From: Laura Gibbons <Laura.Gibbons@arun.gov.uk>
Sent: 22 June 2021 15:34
To: Planning.Responses <Planning.Responses@arun.gov.uk>
Cc: Amy Myer <Amy.Myer@arun.gov.uk>
Subject: RE: Planning Consultation on: Y/80/21/DOC

Condition 7

Application No: Y/80/21/DOC
Registered: 8th June 2021
Site Address: Land East of North End Road and West of Church Lane Nursery Yapton BN18 0GA
Description of Works: Approval of details reserved by condition imposed under ref Y/18/20/PL relating to Condition Nos 7 - surface water drainage and 8 - maintenance & management of surface water drainage.

KEY	
	Location of soakaway tests Result & Depth shown
	Groundwater monitoring results depth of highest recorded level

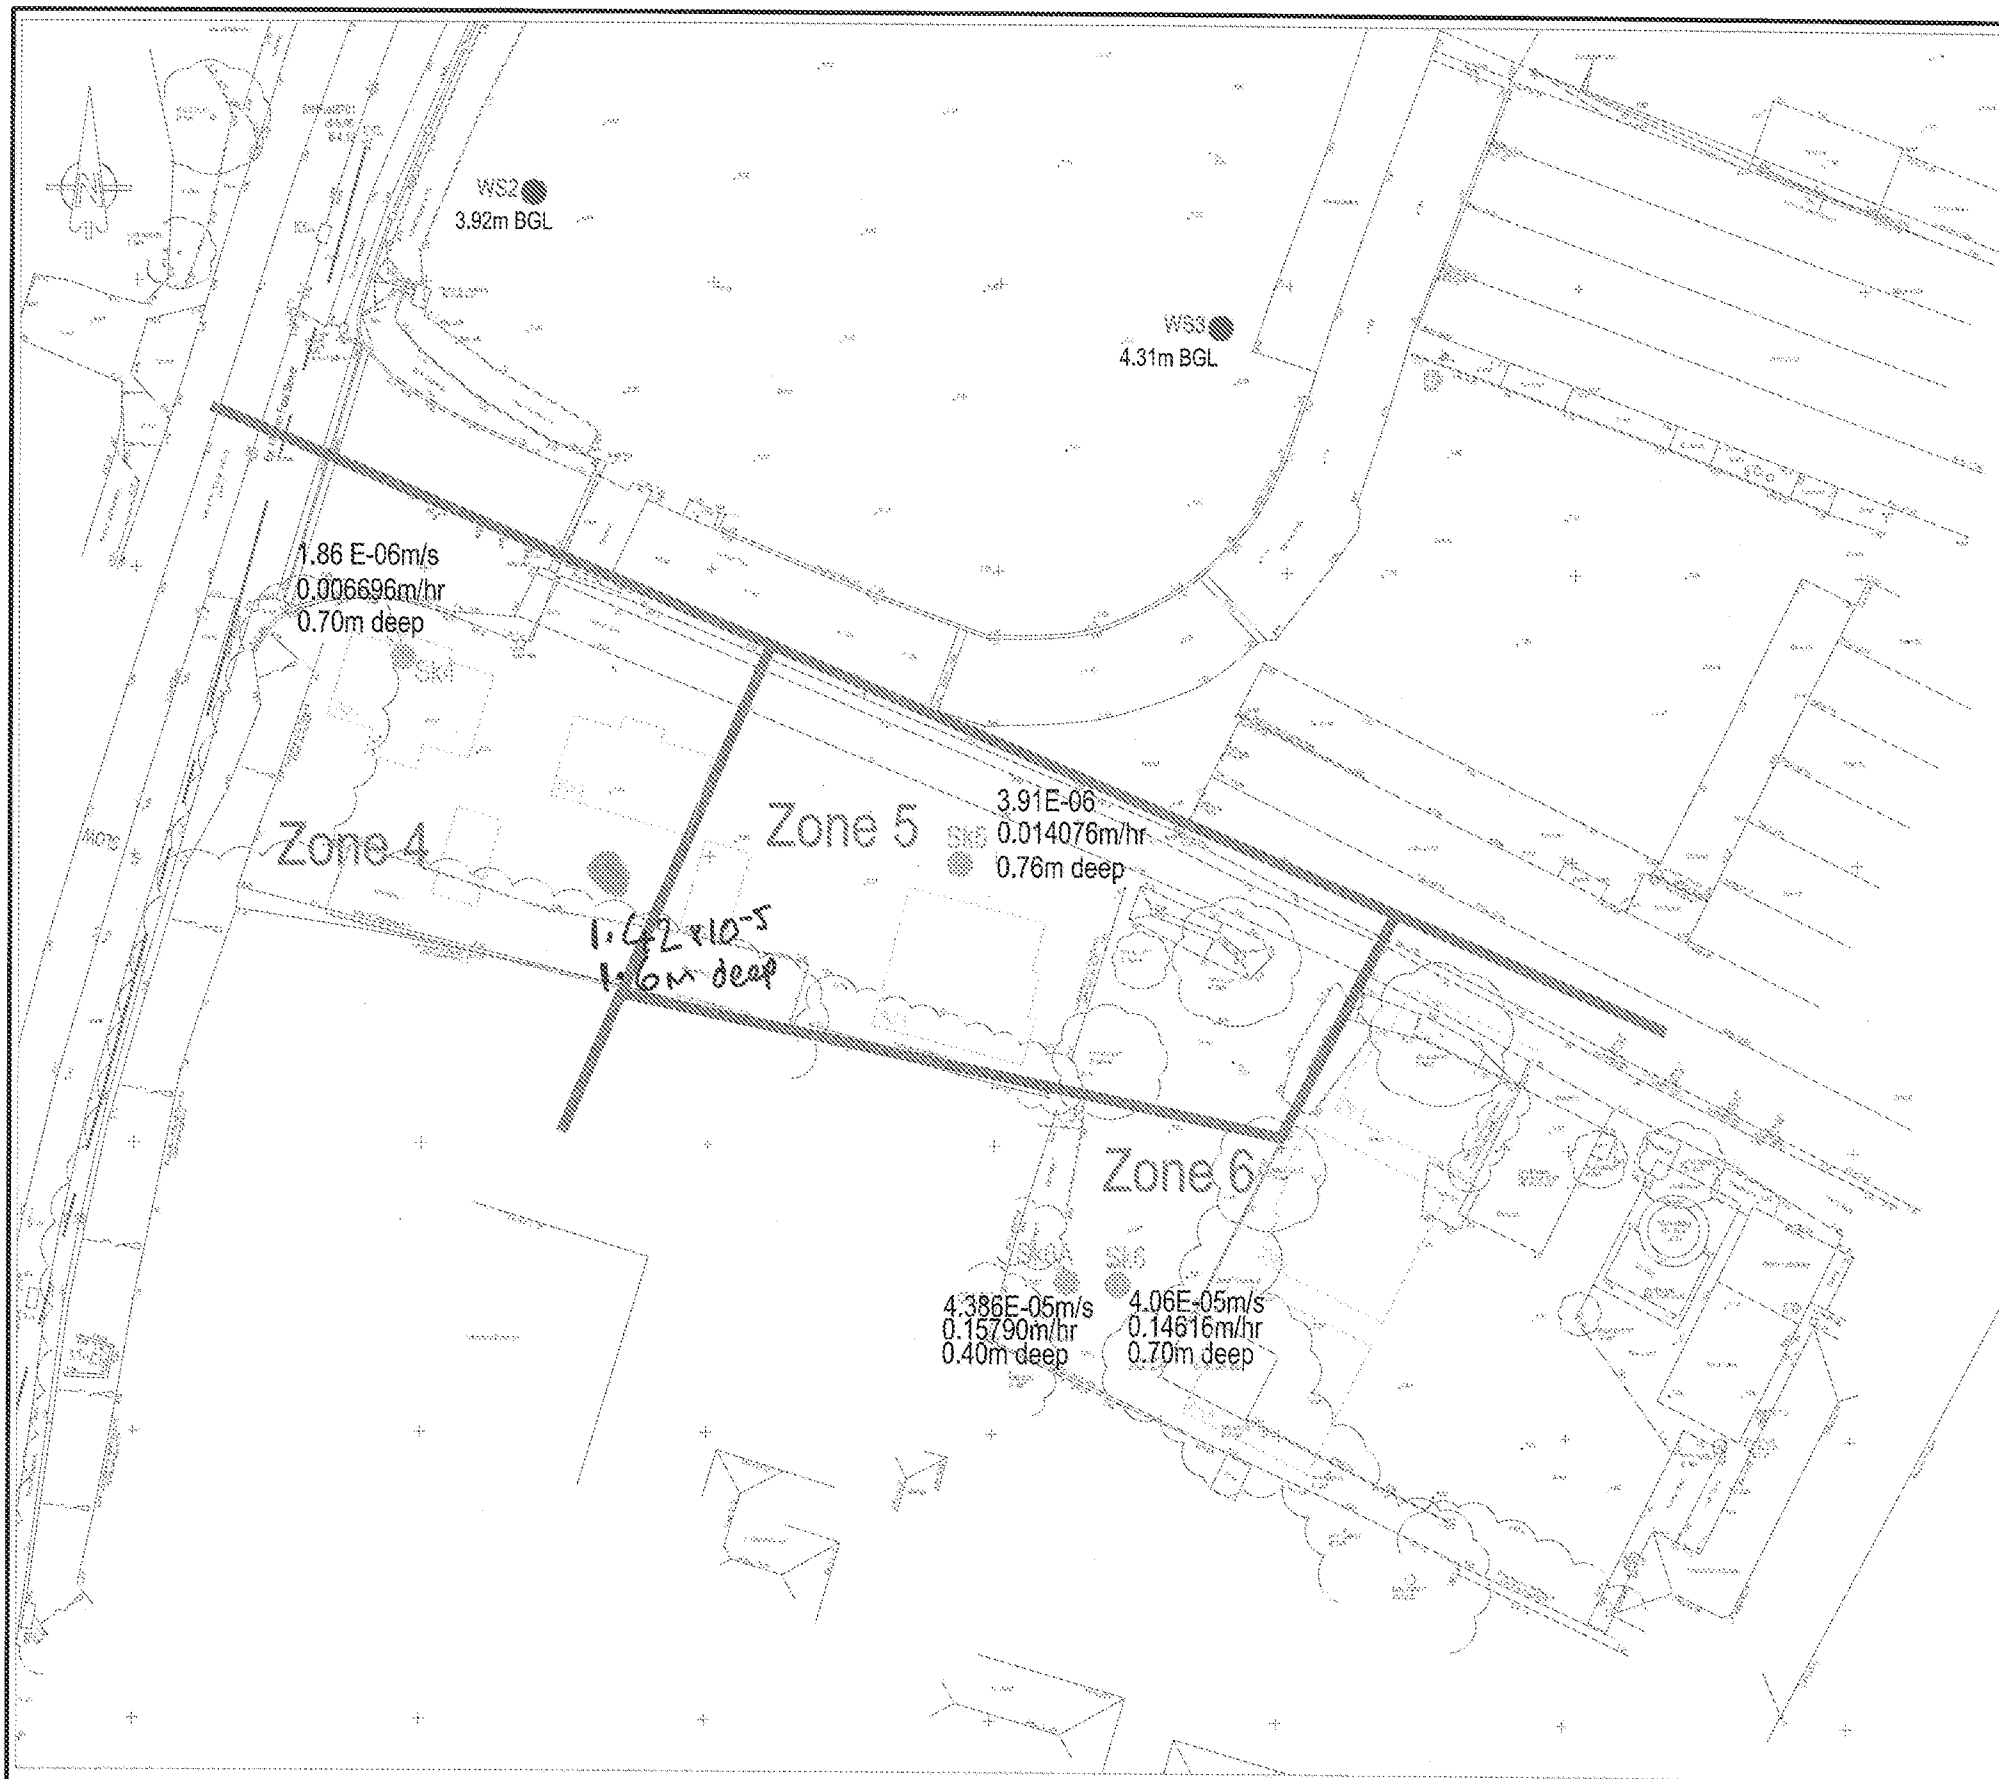
1. Please can the applicant confirm the date of infiltration testing. Please also confirm the location at which infiltration testing was completed.
2. Infiltration testing was completed at 1.6m deep, yet permeable paving formation is proposed at only 430mm depth. Please provide infiltration testing results at shallow depth, or provide linkages to the deeper tested strata.
3. Please detail finish and formation level of permeable paving on plan.
